**KIRKLEES METROPOLITAN COUNCIL
INVESTMENT & REGENERATION SERVICE**

DELEGATED DECISION TO DETERMINE PLANNING APPLICATIONS

Reference No:	2023/62/93800/W
Site Address:	46, Liphill Bank Road, Holmfirth, HD9 2LQ
Description:	Erection of infill extension to form new porch and associated alterations
Recommending Officer:	Laura Yeadon

HOUSEHOLDER DELEGATED REPORT

Drawing Number
 23_819_101

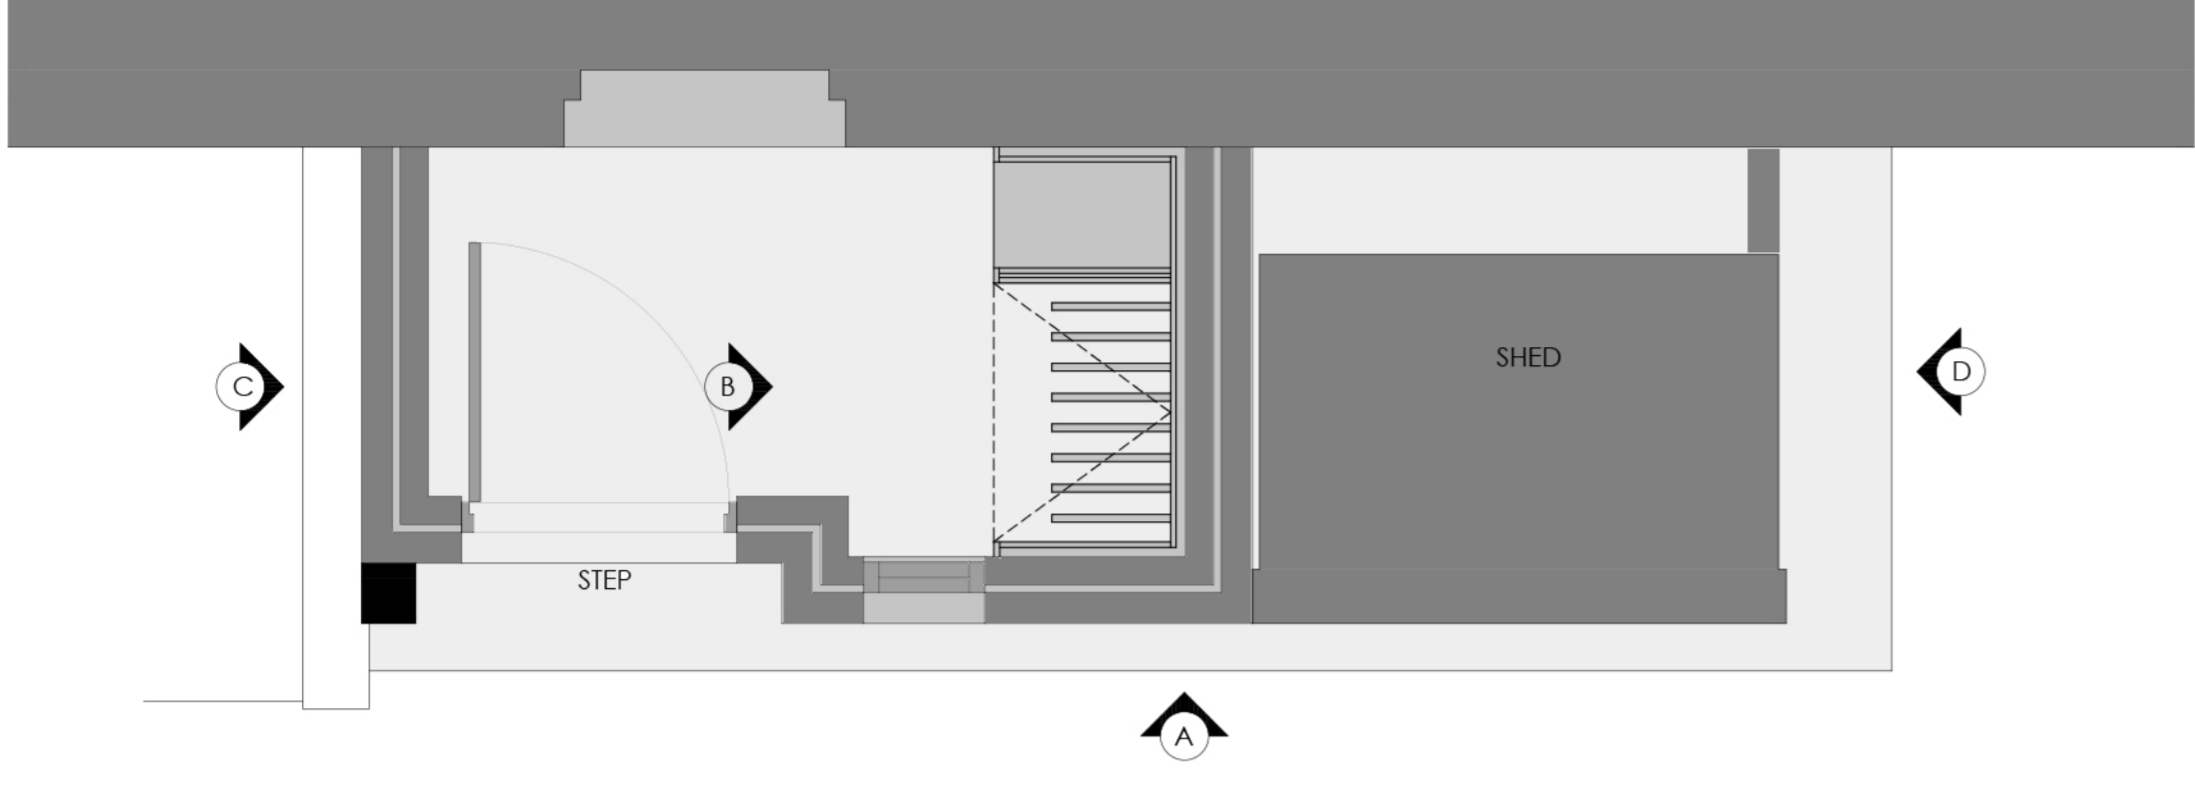
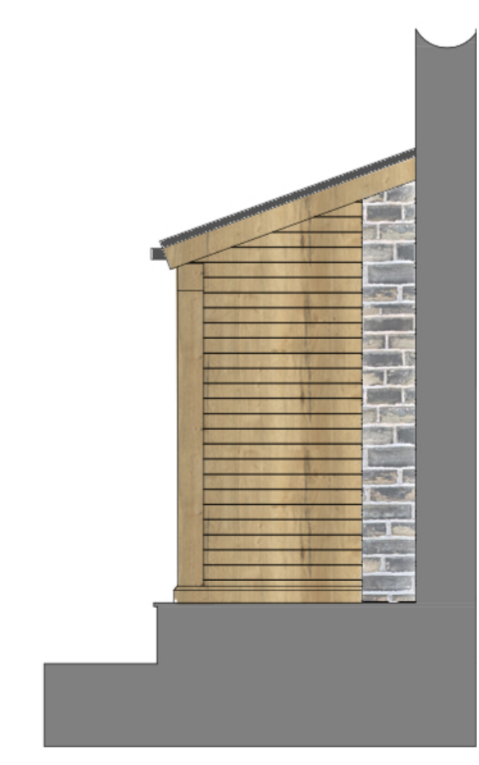
Officer note: *It is noted that the submitted plans indicate that the north facing elevation is the front elevation of the property however, due to the character of the dwelling it is considered that the south facing elevation is the principal elevation of the property and therefore Officers consider that the proposed infill extension would be located on the rear elevation of the dwelling.*

Relevant key design principle (KDP) of the SPD, Policy in the Kirklees Local Plan and the NPPF	Further comments	✓ / X / N/A
Impact on the Local character and street scene	• KDP1 of the SPD • Policy LP24 Design (a) and (c) of the KLP • Policy 1 & 2 of the HVNDP • Chapter 12 NPPF	Limited projection of 1.6 metres. Limited view from public vantage points due to topography of the site. Subservient structure by virtue of being a single storey infill extension	✓
Impact on original house	• KDP2 of the SPD • Policy LP24 Design (c) and (d) of the KLP • Policy 1 & 2 of the HVNDP • Chapter 12 of the NPPF	Subservient due to being single storey – materials to match host dwelling and existing oak shed structure.	✓
Height, scale and massing	• KDP 1 and 2 of the SPD • Policy LP24 Design (a), (c) and (d) of the KLP • Policy 1 & 2 of the HVNDP • Chapter 12 of the NPPF	Single storey and part width of north-facing elevation forming an infill extension between the existing shed and boundary wall	✓

Facing materials and detailing	• KDP 9 of the SPD • Policy LP24 Design (d) (iii) of the KLP • Policy 1 & 2 of the HVNDP • Chapter 12 of the NPPF	Materials to match to the proposed element of the scheme.	✓
Roof style	• KDP 1 and 2 of the SPD • Policy LP24 Design (a), (c)	Simple lean-to structure with roof materials to match the existing roof of the dwelling	✓

and (d) of the KLP • Policy 1 & 2 of the HVNDP • Chapter 12 of the NPPF		
Window proportions	• KDP 1 and 2 of the SPD • Policy LP24 Design (a), (c) and (d) of the KLP • Policy 1 & 2 of the HVNDP • Chapter 12 of the NPPF	Small window proposed within the north facing elevation	✓
Accessibility for all users	• KDP 17 of the SPD • Policy LP24 Design (f) • Policy 1 & 2 of the HVNDP • Chapter 12 of the NPPF	Private domestic extension – no alterations to general access arrangements	✓

Relevant key design principle (KDP) of the SPD, Policy in the Kirklees Local Plan and the NPPF	Further comments	✓ / X / N/A
Impact on privacy of neighbours (to	• KDP 3 & 4 of the SPD	Side elevation facing No. 44 has a limited projection of 1.6 metres	✓

3. Other than the areas indicated to be timber, detailed on submitted drawing 23_819 101, the external walls and roofing materials of the extension hereby approved shall in all respects match those used in the construction of the existing building.
